Project Name: LaQuinta Hotel & Stormwater Renovation  
Address: 340 Park Avenue  
Applicant: Ted Czyzewski  
Planner: Matthew Grooms

Project ID: 2017-007

RE: Staff Review Comments for 340 Park Avenue – LaQuinta Hotel Stormwater Renovation  
(2017-007)

Subject: Comment Response Letter  
Hotel Renovation & Stormwater Upgrade at La Quinta - Portland, Maine

Drawing file: 1. Original Plans / C-30 Grading & Drainage Plan.pdf

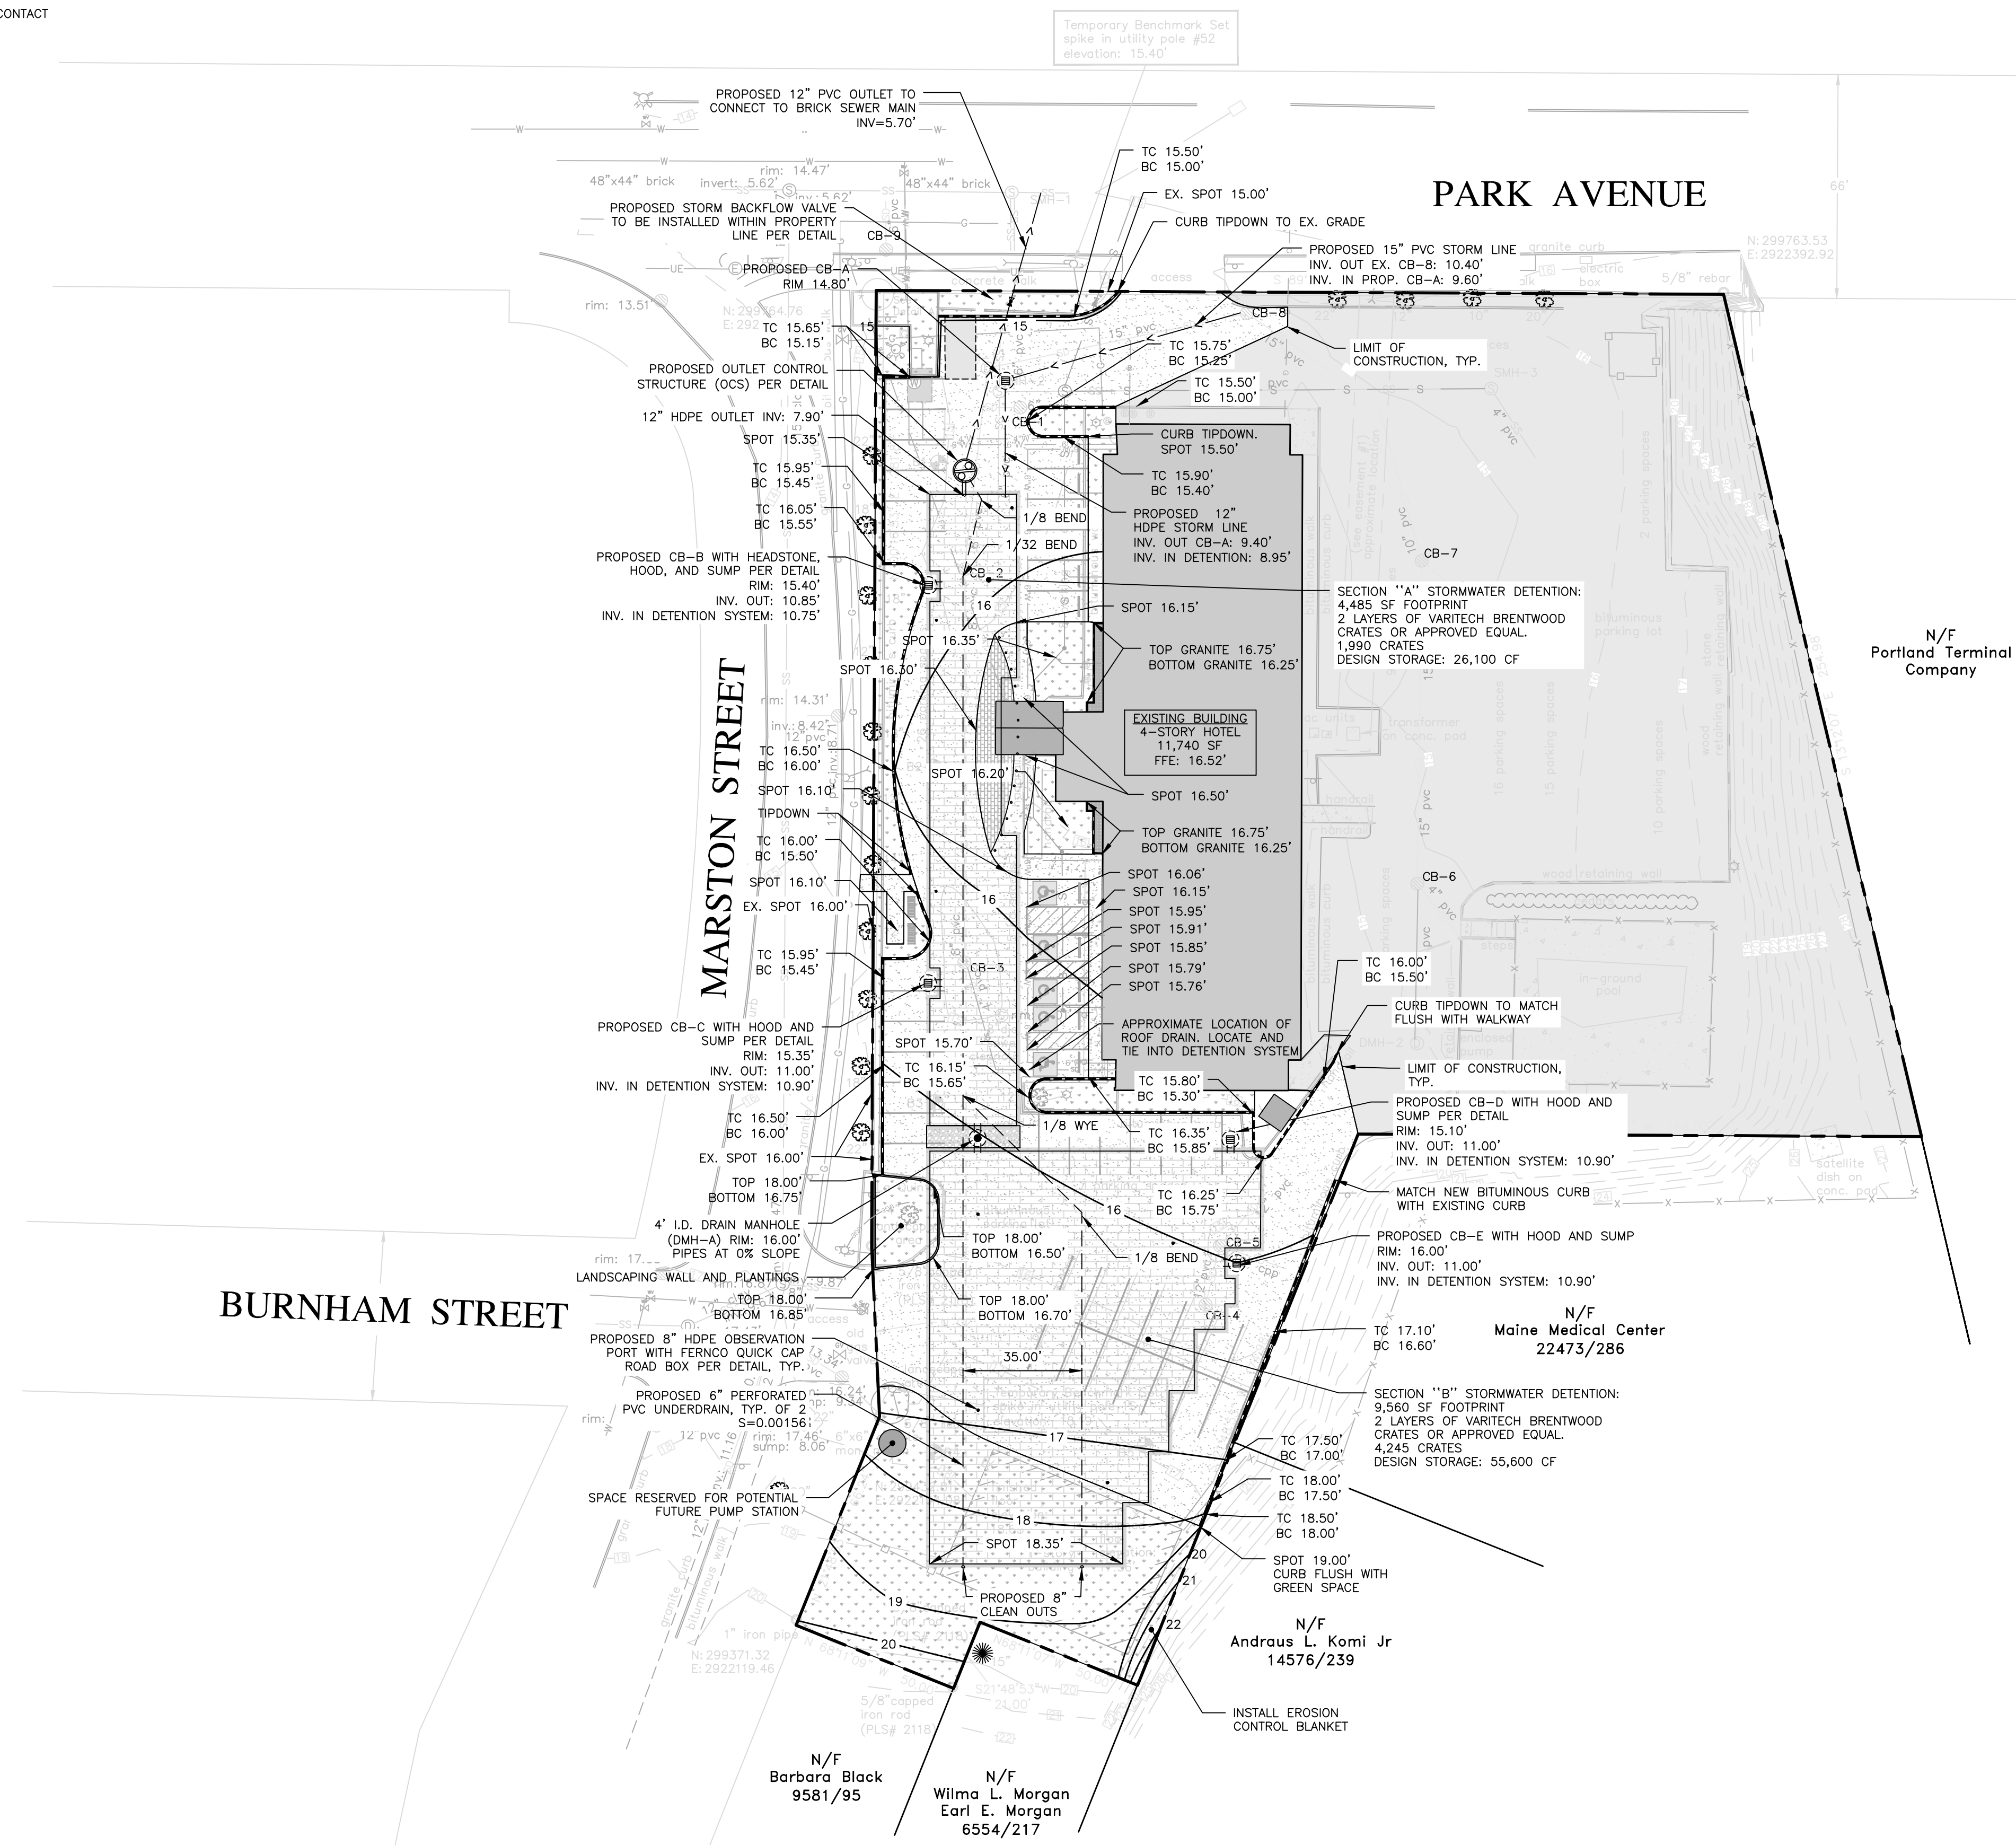
3. The proposed storm drain connection to the combined sewer is not currently in conformance with the City of Portland Technical Standards. HDPE pipe is not typically allowed within the City of Portland Right-of-Way, and connections are not typically allowed to manhole structures. The Applicant may request consideration of a waiver; however, additional review of the means for connection by Public Works will be required.

**Comment 3 –** *The proposed storm drain connection to the combined sewer is not currently in conformance with the City of Portland Technical Standards. HDPE pipe is not typically allowed within the City of Portland Right-of-Way, and connections are not typically allowed to manhole structures. The Applicant may request consideration of a waiver; however, additional review of the means for connection by Public Works will be required.*

**Response –** Acorn has requested input from the Public Works, but none has been received to date. In order to address the noted conflict with Technical Standards, the storm drain connection now incorporates PVC instead of HDPE, and the angle of the pipe had been modified so that it connects straight to the combined sewer main and not the manhole. Refer to the Grading and Drainage Plan, Sheet C-30.
